Please ask for: Sian Eggington
Email: sian.eggington@terraquest.co.uk
Telephone: 0121 2341390
Our Ref: R/79/21/HH
Your Ref:
Date: 21st April 2021

Application for Planning Permission for Works or Extension to a Dwelling

Development: Single storey rear extension to semi-detached house
Location: 31 Broadmark Lane Rustington BN16 2HD

DRAWING TITLE:
Existing and Proposed
Side Elevation

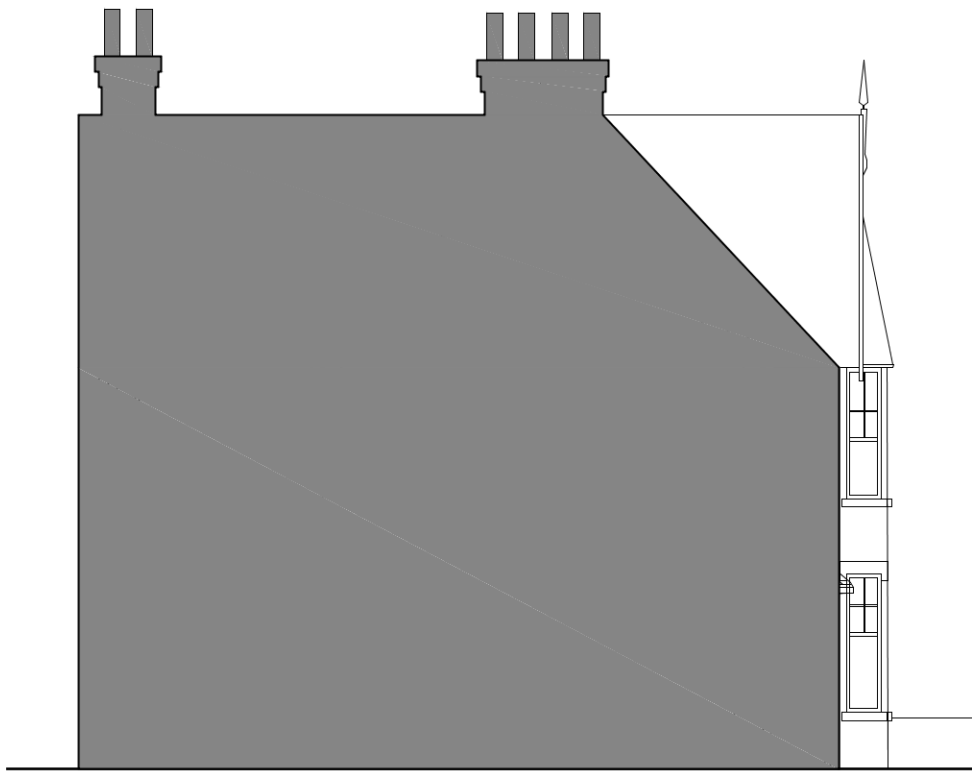
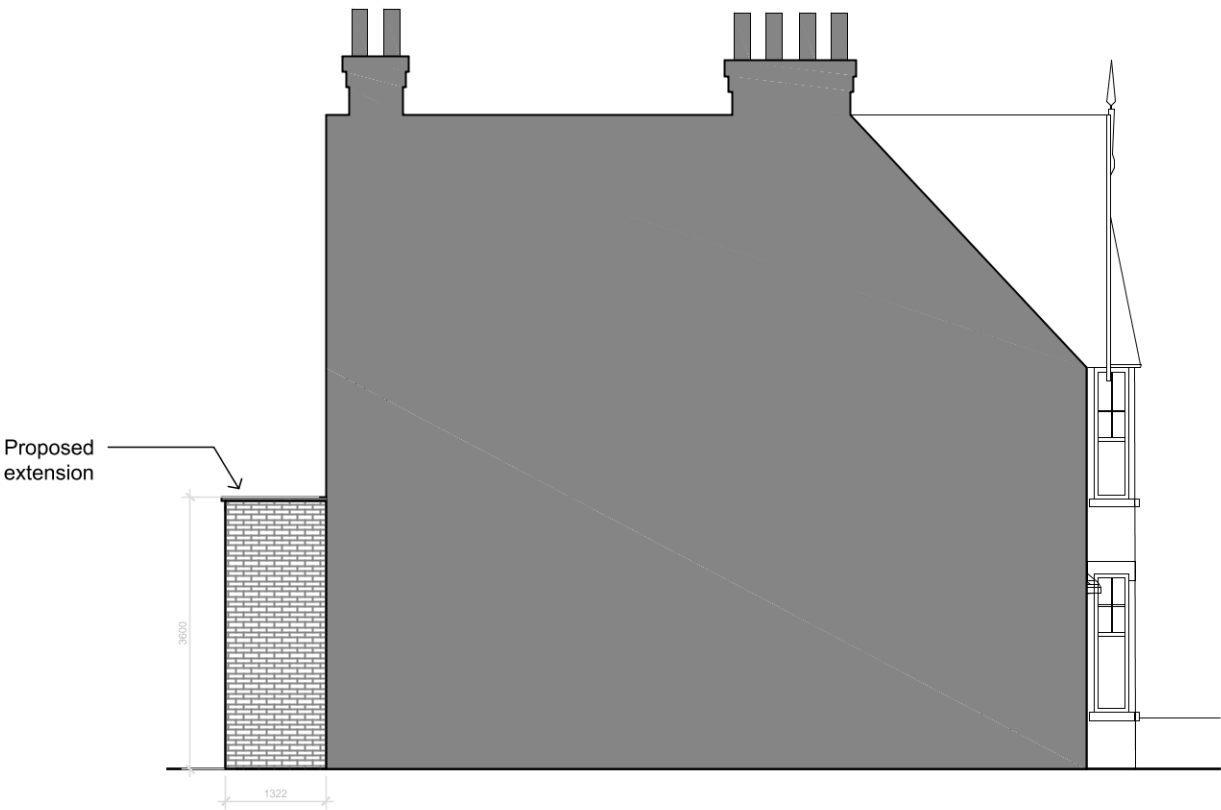
Elevations

Please submit a copy of clearly labelled existing and proposed other side elevations at a scale of 1:50 or 1:100. Further details can be found in the Validation Requirements List.

Rev	Date / Initials	Details
MICHAEL FRIEL ARCHITECTS		
PROJECT TITLE:		
31 BROADMARK LANE EXTENSIONS AND ALTERATIONS		
DRAWING TITLE:		
Location and Block Plan		
DRAWING No:	REVISION:	
PL-001	A	
DATE:	STATUS:	
21.04.21	Planning	
JOB No:	SCALE:	
08	1:1250 and 1:500 @ A3	
DRAWN:	CHECKED:	
MF

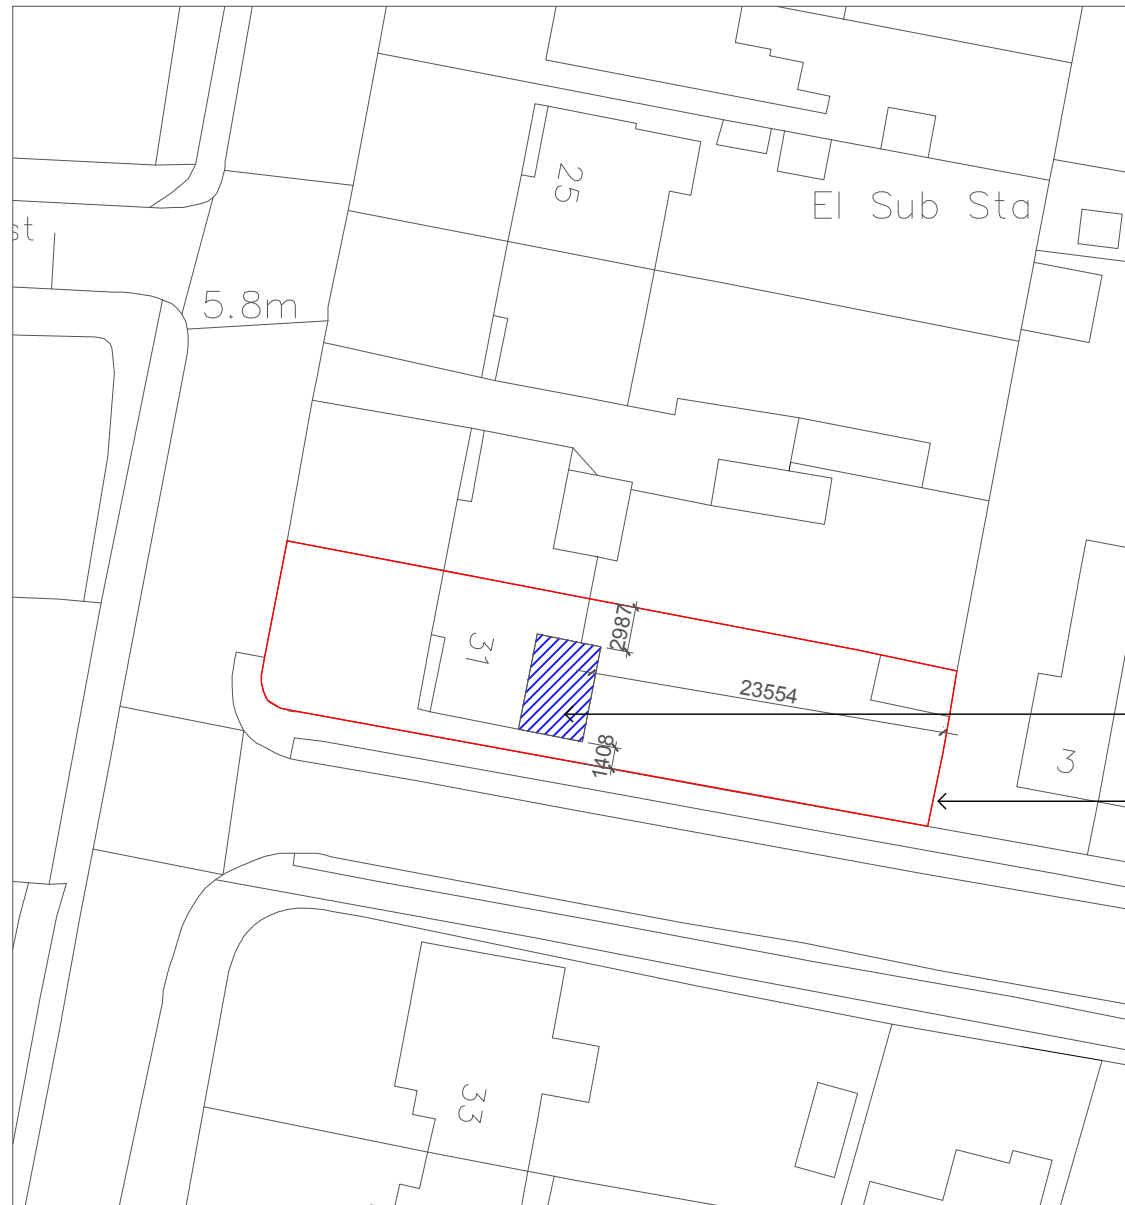
Block Plan

You are required to have dimensions from the proposed extension(s) to all site boundaries. Please amend.
